**From:** Mundy, Ben - Oxfordshire County Council <Ben.Mundy@Oxfordshire.gov.uk>  
**Sent:** 01 August 2022 16:06  
**To:** DC Support; Shona King  
**Cc:** Transport CDC Minor  
**Subject:** 22/01924/DISC Jacobs Douwe Edberts, Ruscote Avenue, Banbury, Oxfordshire, OX16 2QU  
**Attachments:** Comments for CTMP for Jacobs Douwe Edberts Ruscote Avenue Banbury Oxfordshire OX16 2QU.docx

**Planning Application: 22/01924/DISC**

**Location:** Jacobs Douwe Edberts, Ruscote Avenue, Banbury, Oxfordshire, OX16 2QU

**Description:** Discharge of Conditions 3 (car parking provision), 6 (construction traffic management plan) and 10 (tree pits) of 21/04144/F

TITLE  
**Proposed External Finishes**

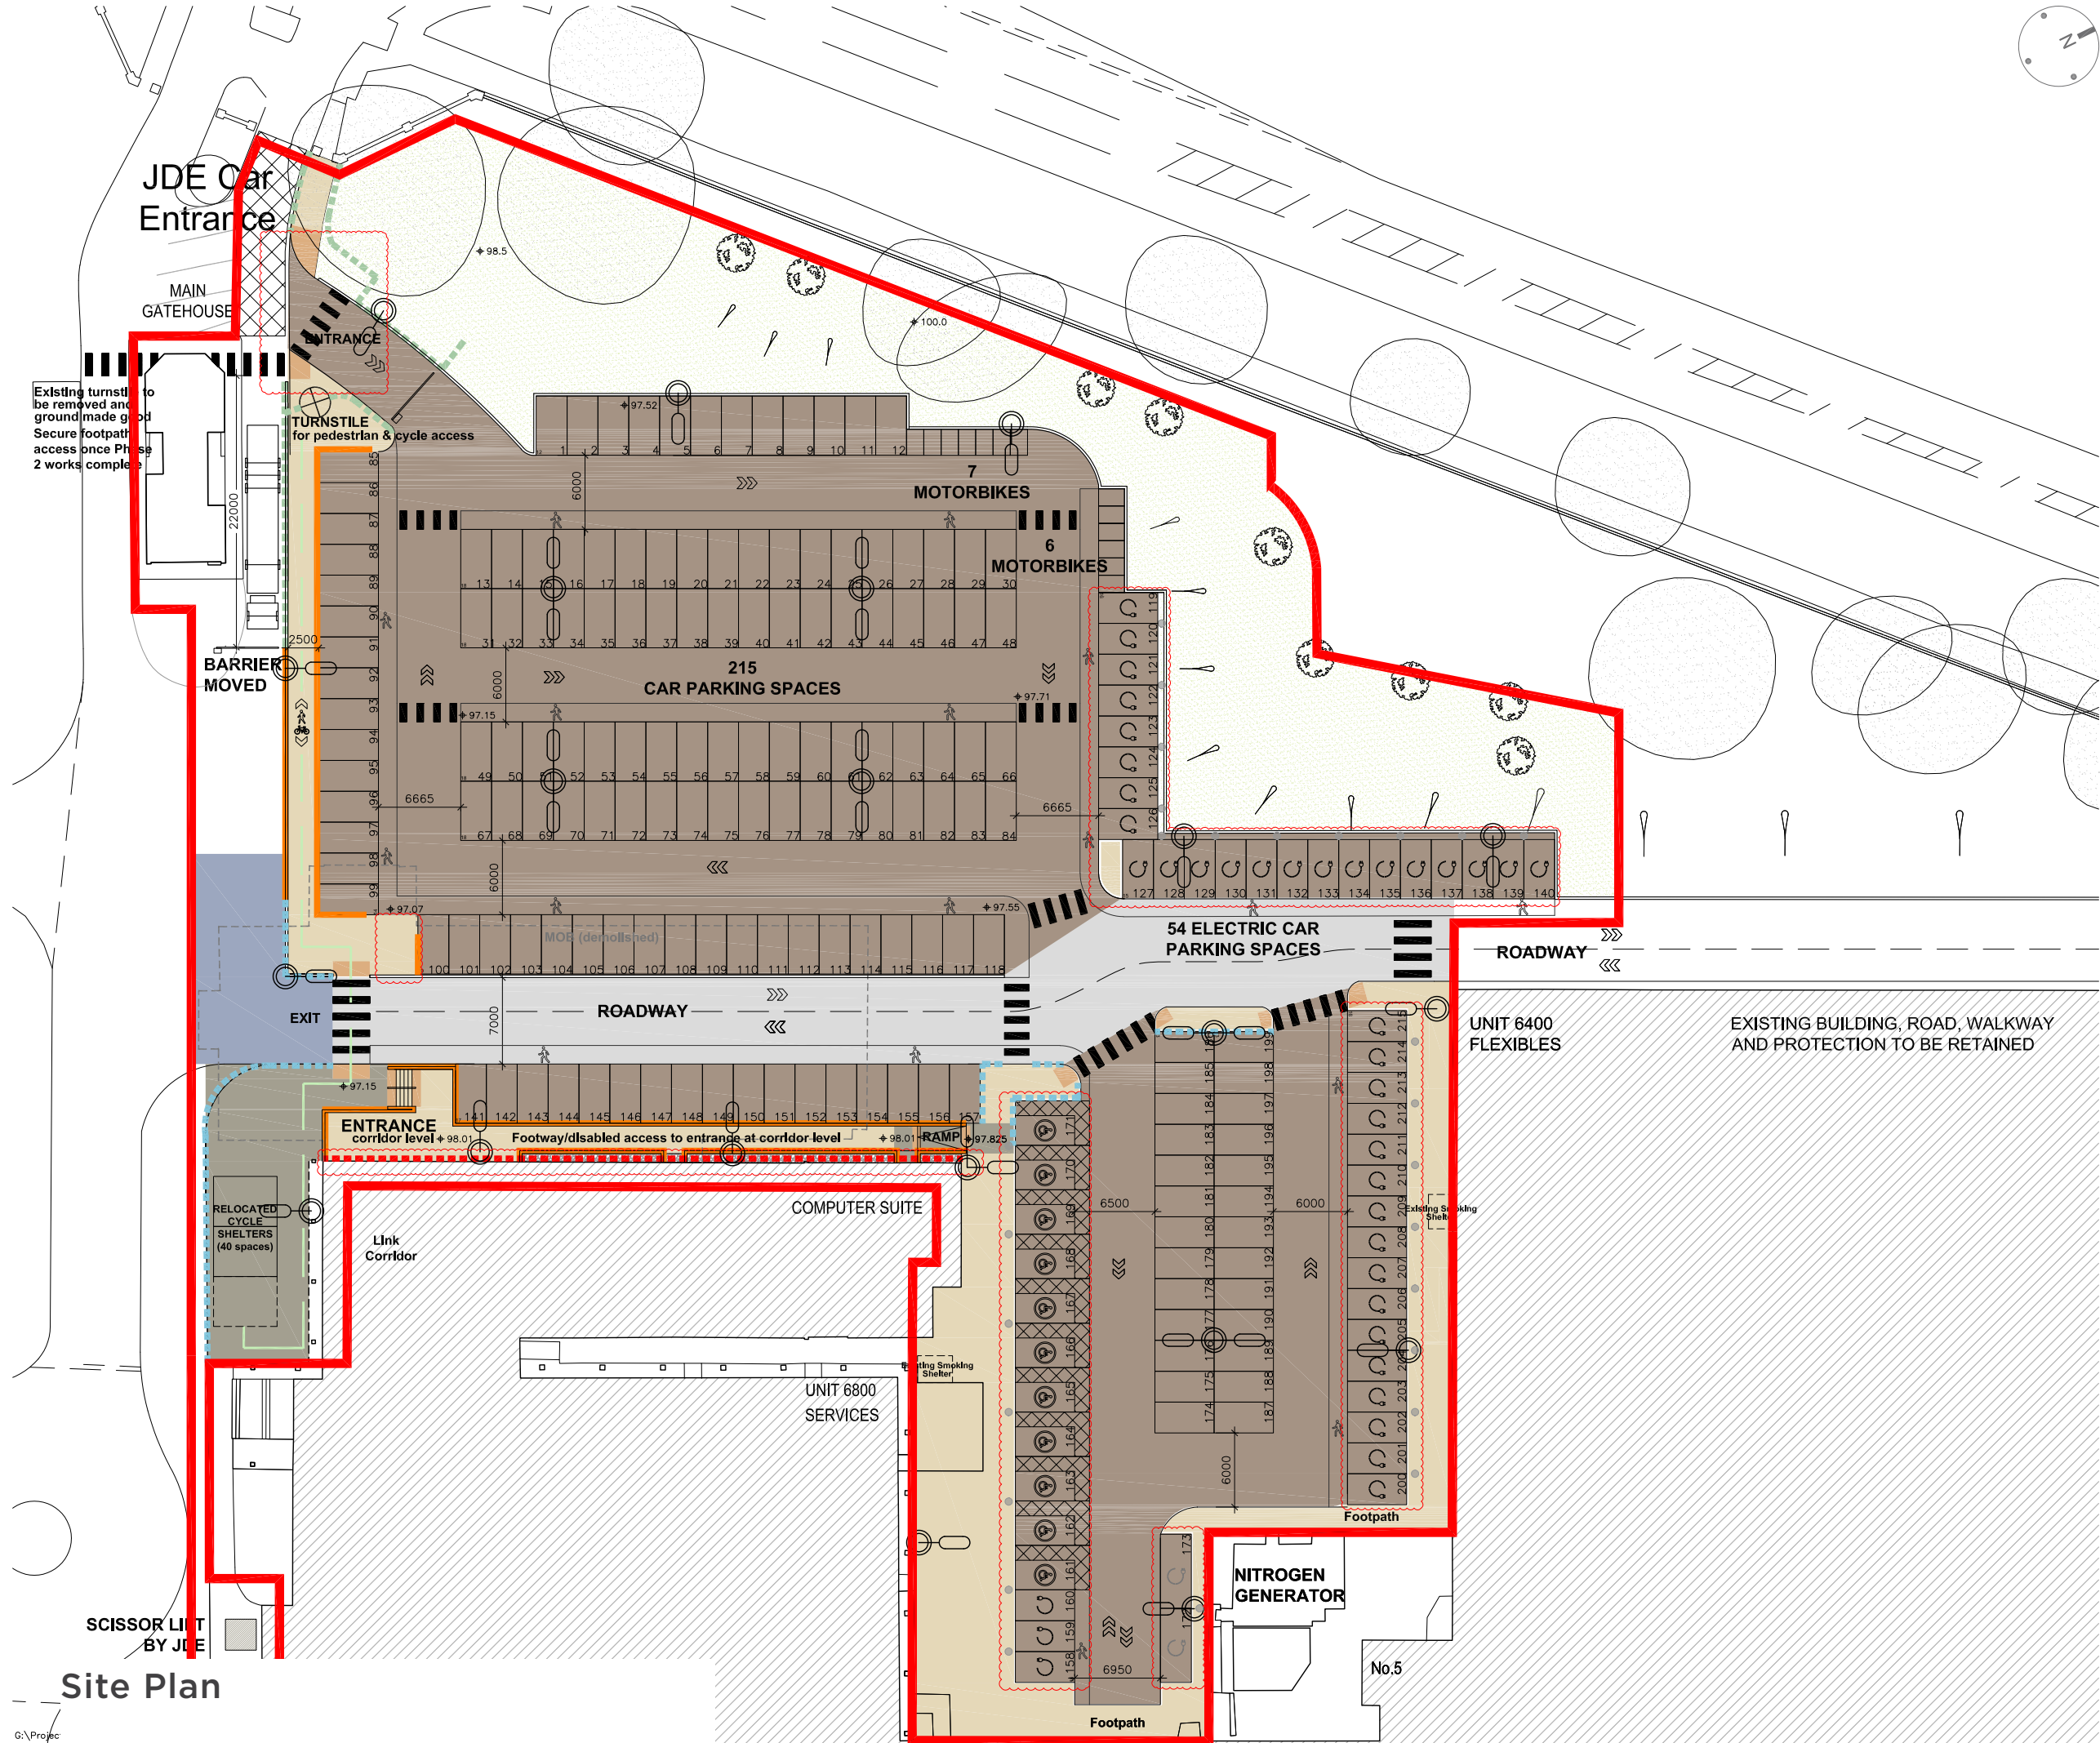
- OCC are satisfied that the width of the parking space conforms to guidance set out within OCC parking policy.
- OCC are also satisfied that a gap of 6.0m has been implemented so that cars have adequate space to manoeuvre into spaces safely.
- Disabled spaces are adequately placed and are of size.
- E/V charging spaces are of adequate quantity.
- The drainage and tree section of this application is probably best looked at by the drainage and tree teams respectively, as they will be able to give a more informed response.
